Town & Country Planning Act 1990 (as amended)
Town and Country Planning (Development Management Procedure) (England) Order 2015
Application for approval of details imposed under planning permission Y/5/16/PL relating to
Condition 3 (Surface water drainage scheme), 4 (Landscaping scheme), 5 (Tree/root protection & 6
(materials of walls and roofs)
Longacre Maypole Lane, Yapton,

Arun District Council have decided to **APPROVE details reserved by this condition**
The tree protection details as shown on Drawing PJC/4366/17/A "Tree Constraints and Retention Plan" has been agreed by the Councils Tree Officer and it has subsequently been docdeci

Drawing title: Tree Constraints and Retention Plan

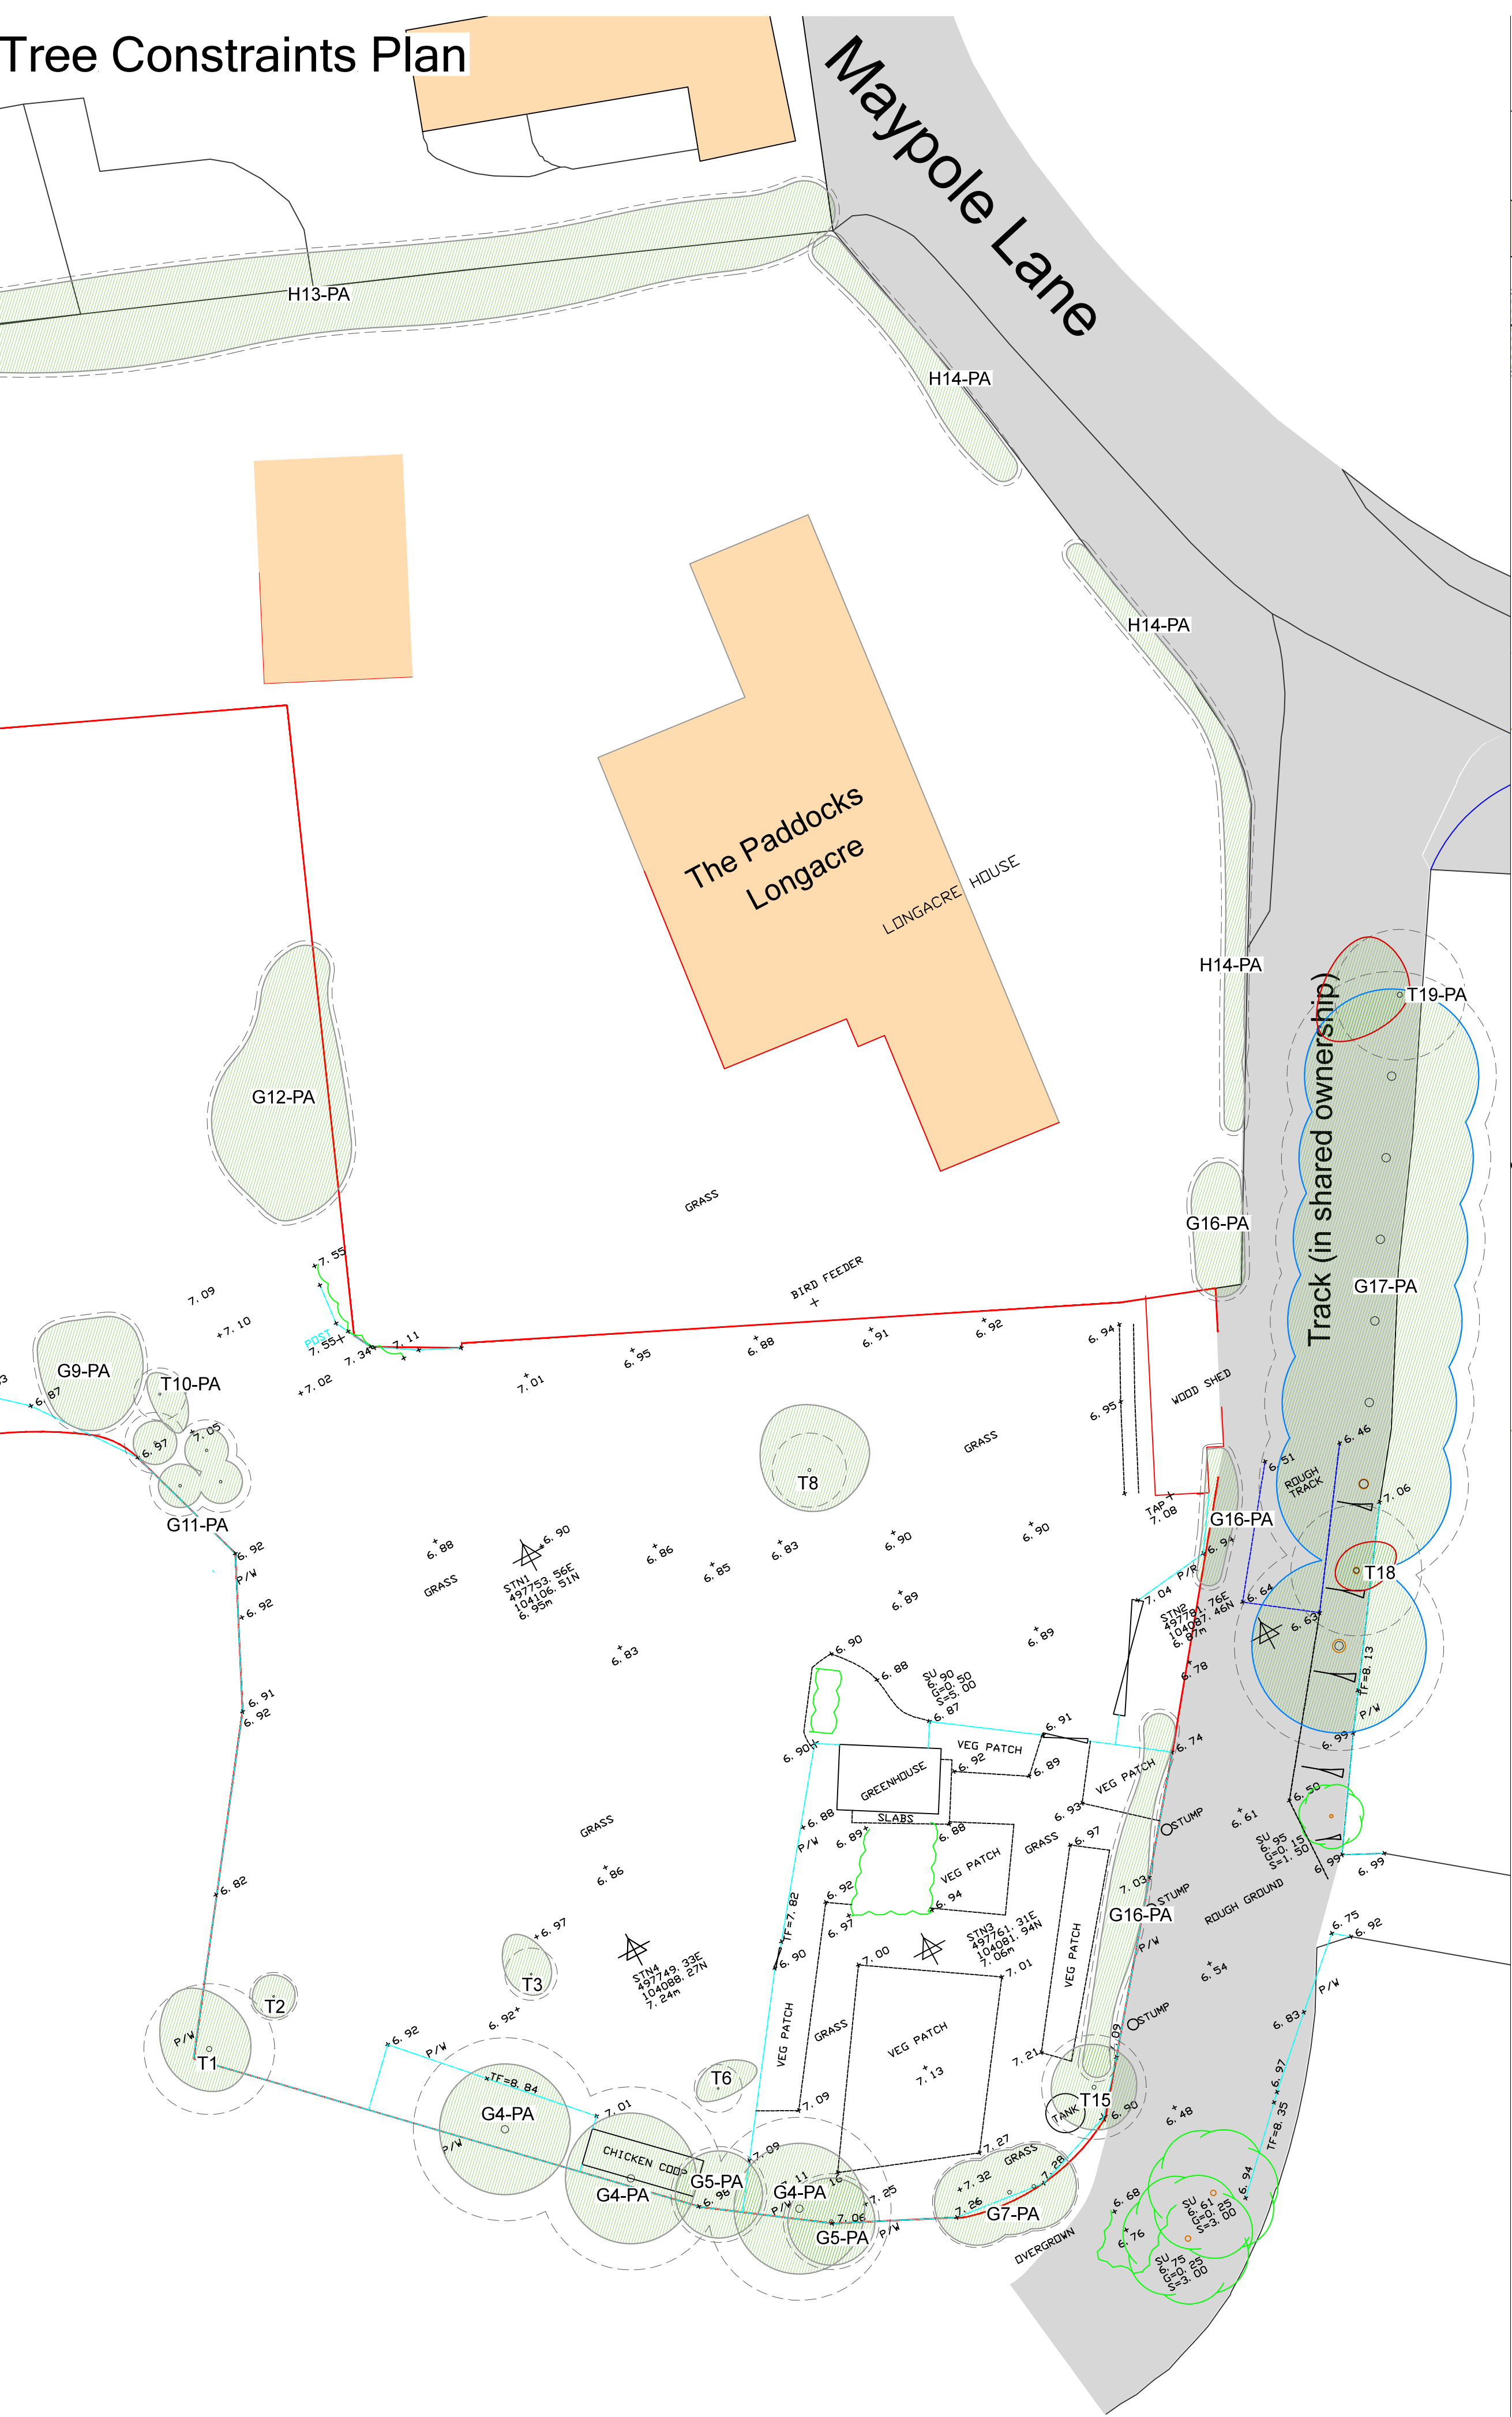
confirmed with photographic evidence that the protection measures are in place.

The condition is therefore fully discharged insofar as the submission of details relates and on the understanding that the trees will continue to be protected throughout the construction of the site.
